**M1 Pacific Motorway extension to Raymond Terrace (SSI 7319)
Advice on the Environmental Impact Statement (EIS)**

Thank you for the request for advice from Public Authority Consultation (PAE-24749572), requesting the review by the NSW Environment Protection Authority (EPA) of the Environmental Impact Statement (EIS) for the proposed M1 Pacific Motorway extension to Raymond Terrace (Application SSI-7319).

ATTACHMENT A: EPA COMMENT ON EIS FOR M1 PACIFIC MOTORWAY EXTENSION TO RAYMOND TERRACE (SSI 7319)

Location: L19 - 2207 Pacific Highway,

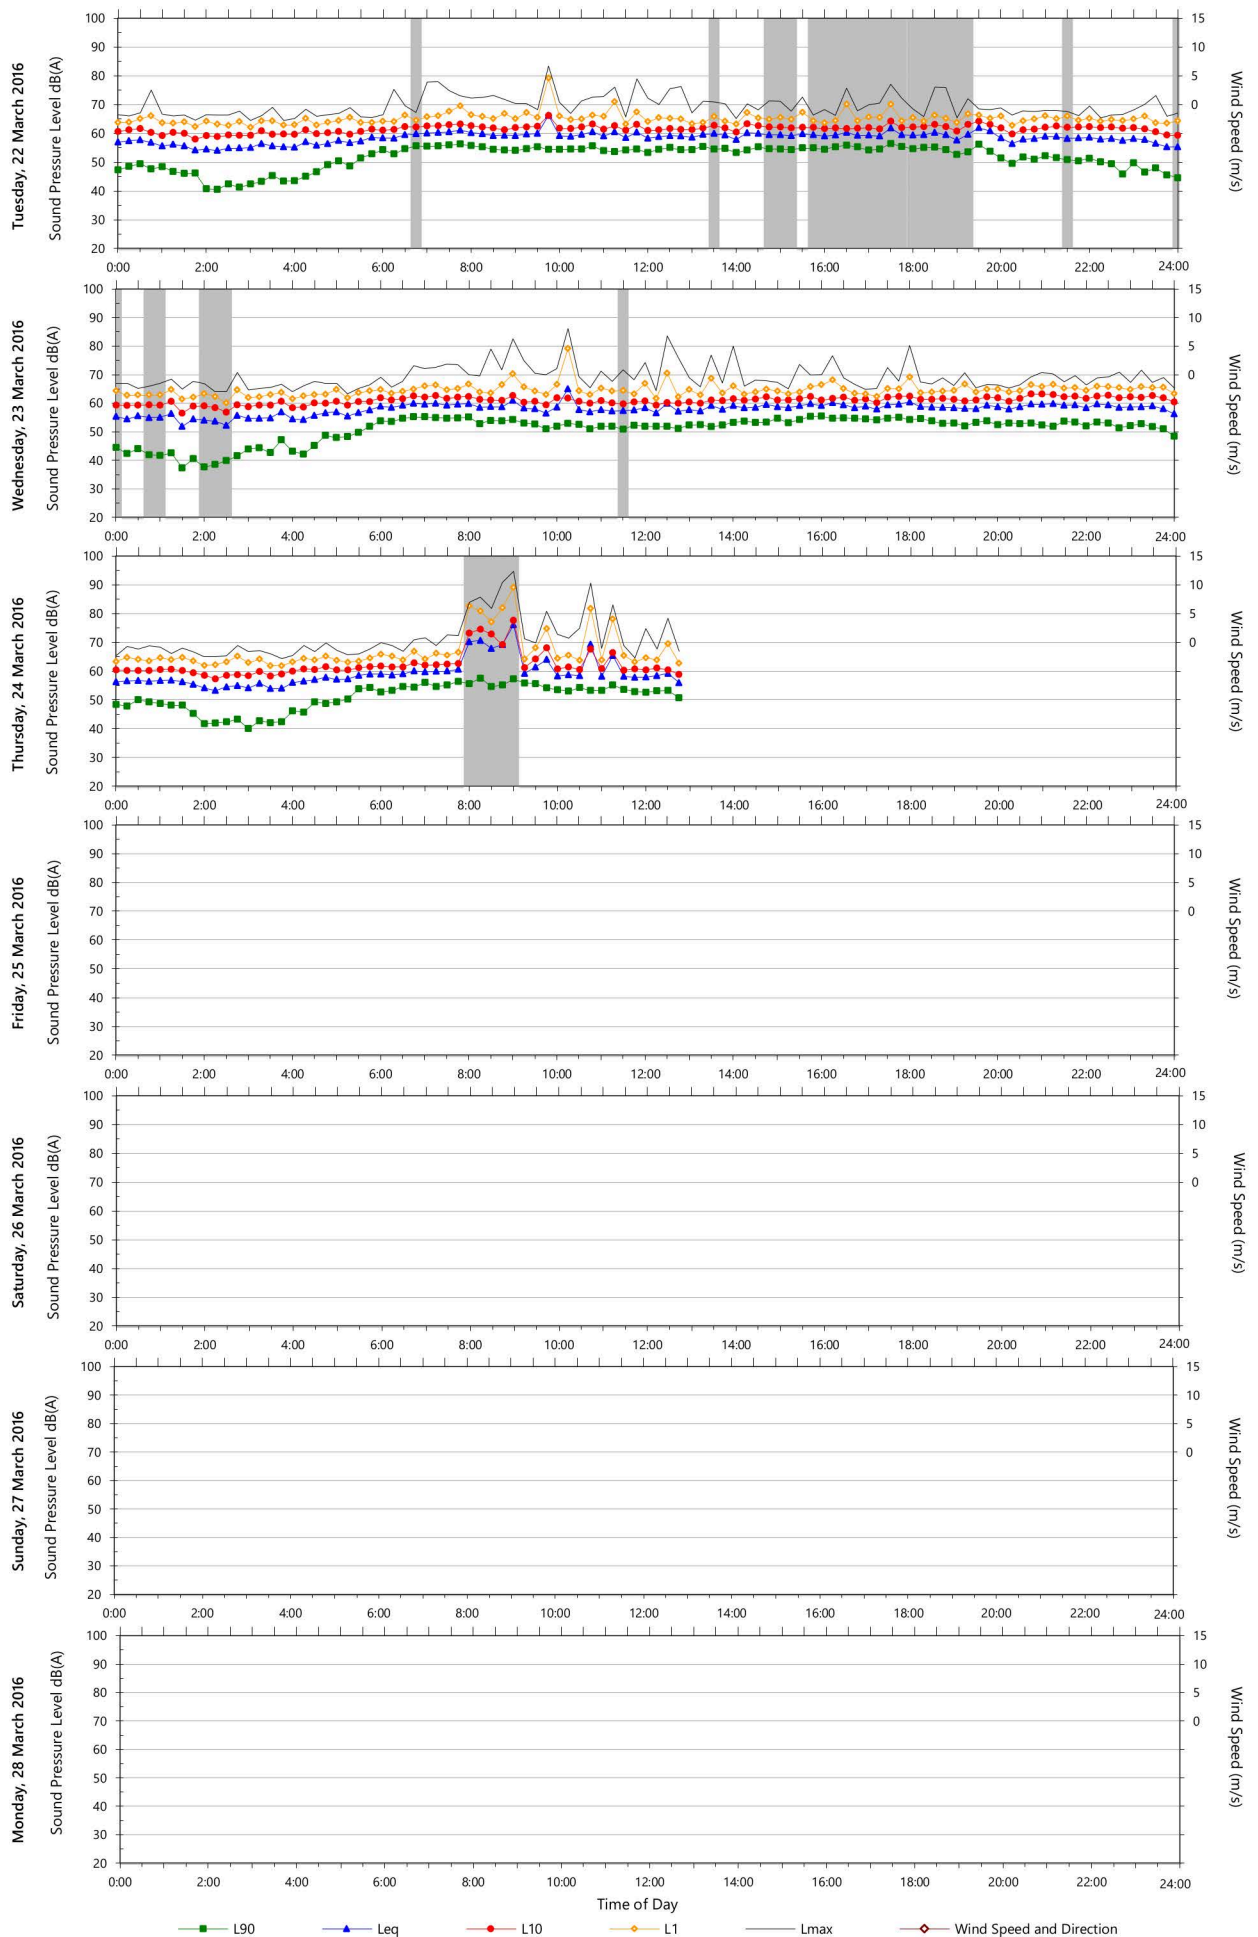
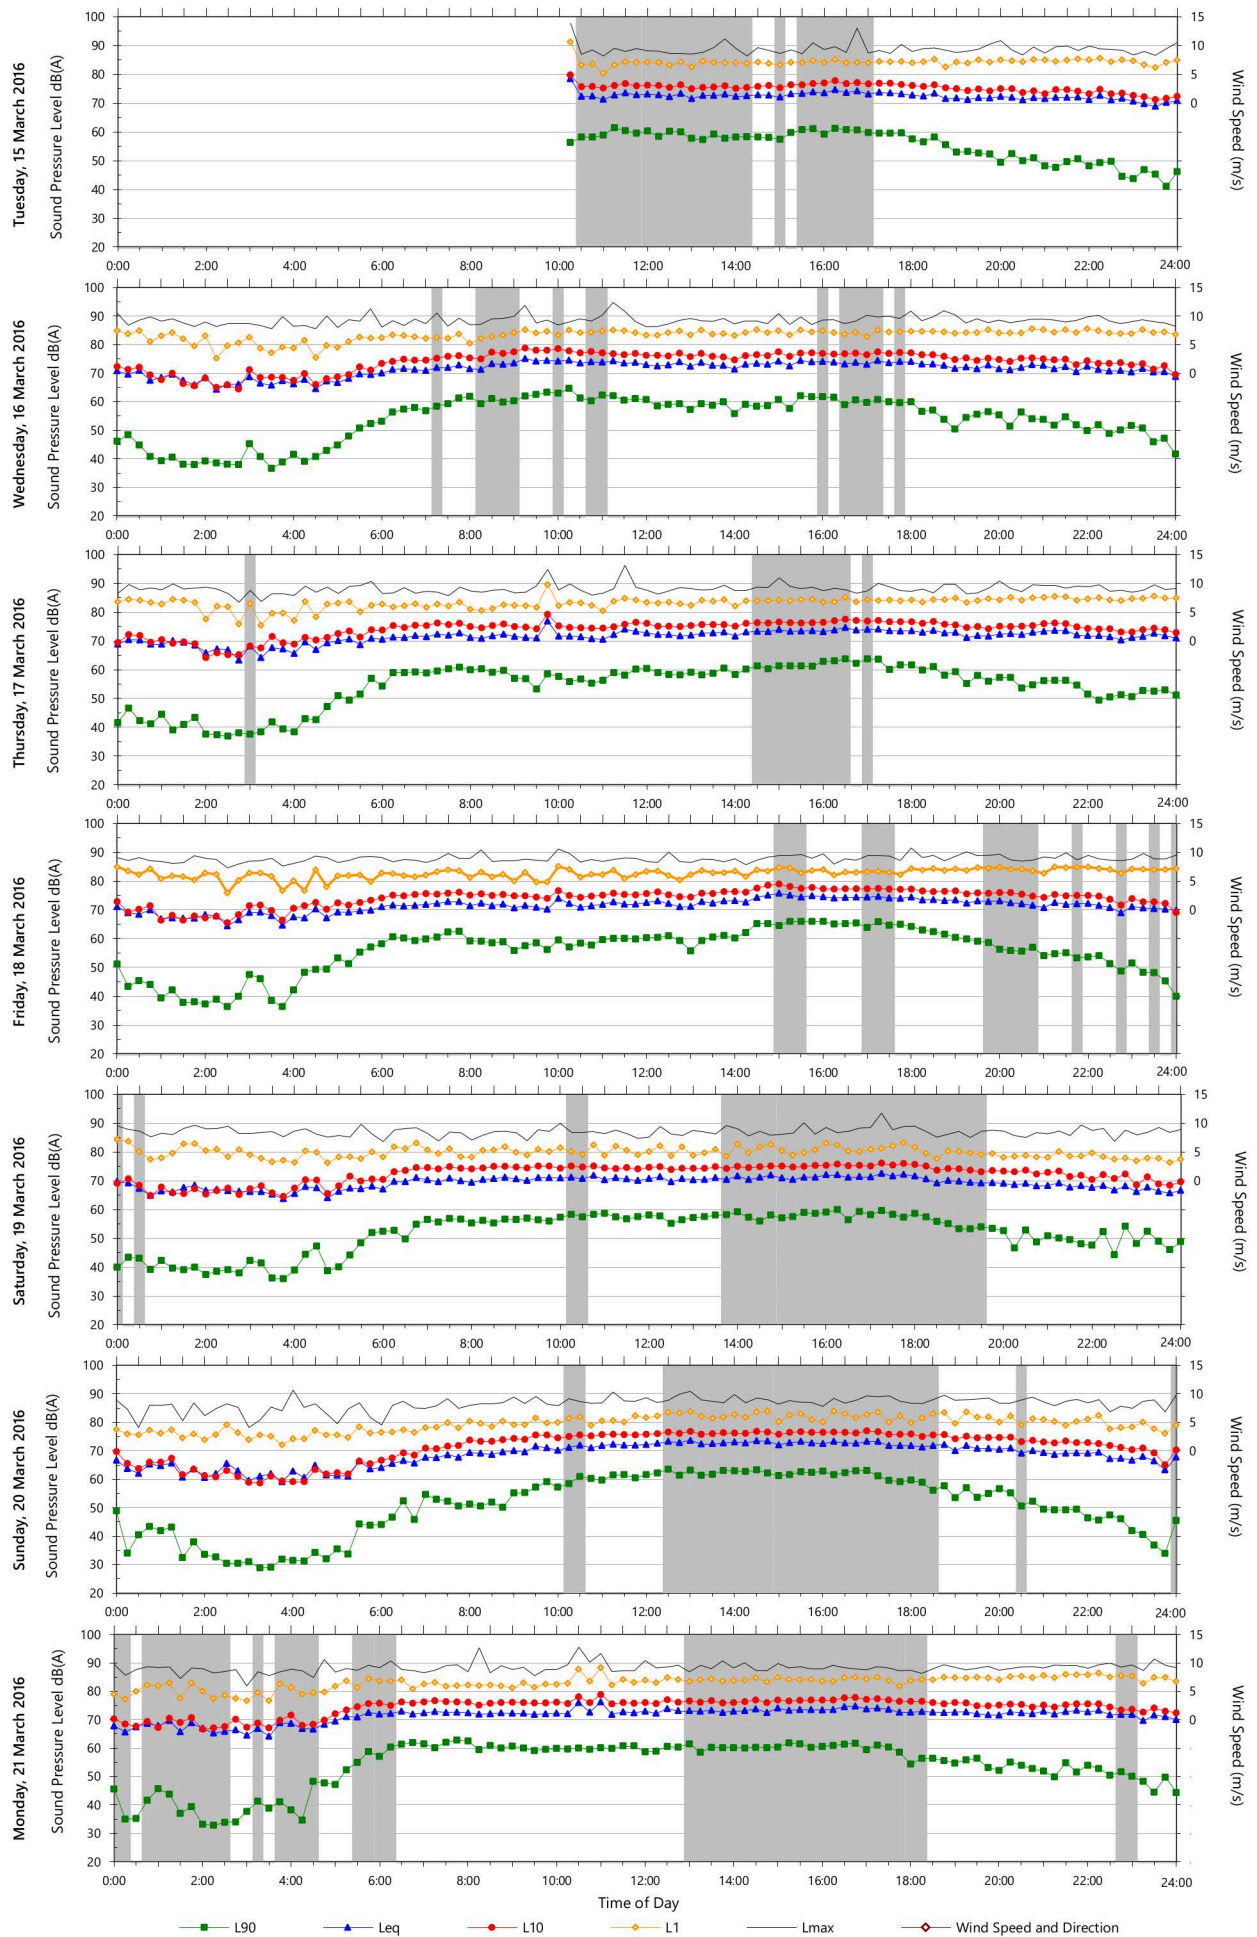
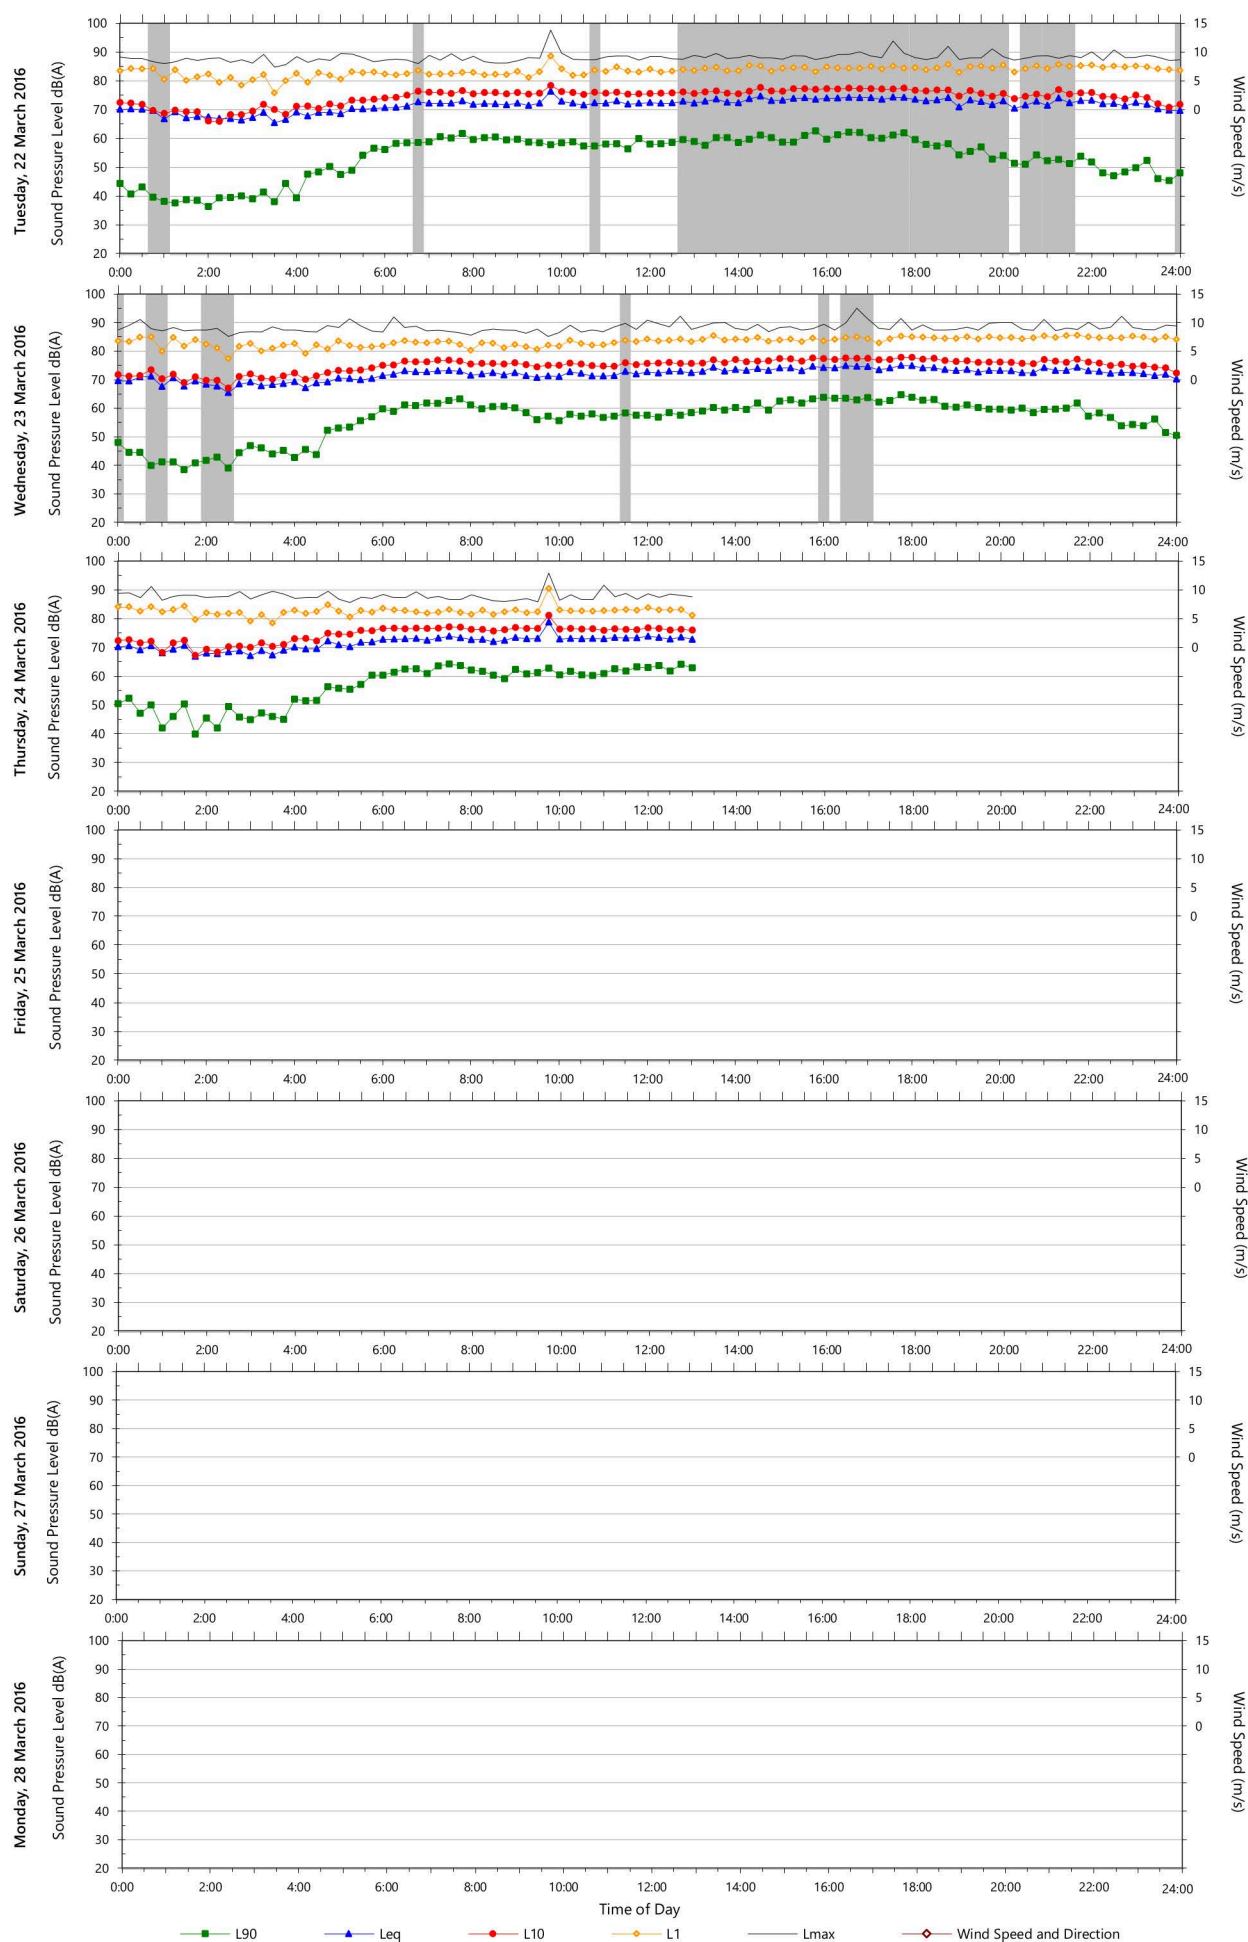
Locations L01 to L014 (inclusive) appear to have no more than 5 and in some cases less than 3 valid periods out of the total monitoring duration. Locations L15 to L20 appear to be less affected, however there it is still not clear if sufficient valid data has been presented.

Noise monitoring was also conducted in 2016 for the purposes of measuring road traffic noise. Due to the amount of data excluded at Locations L13 to L20, further justification is needed that the remaining data, after invalid samples were excluded, provides sufficient amount of data to enable a representative calculation of the traffic noise descriptors.

The proponent reviews the noise monitoring data in the NIA in the context of the monitoring requirements set out in the NPfI and for each location and either:

- Provide a justification and demonstrate that the requirements of the NPfl have been fulfilled; or
- Provide additional data that fulfills the monitoring requirements in the NPfl.

The EPA also recommends that the proponent either:

- Provides justification and demonstrate that the data presented for road traffic noise descriptors is sufficient to be representative; or
- Provides additional valid data.
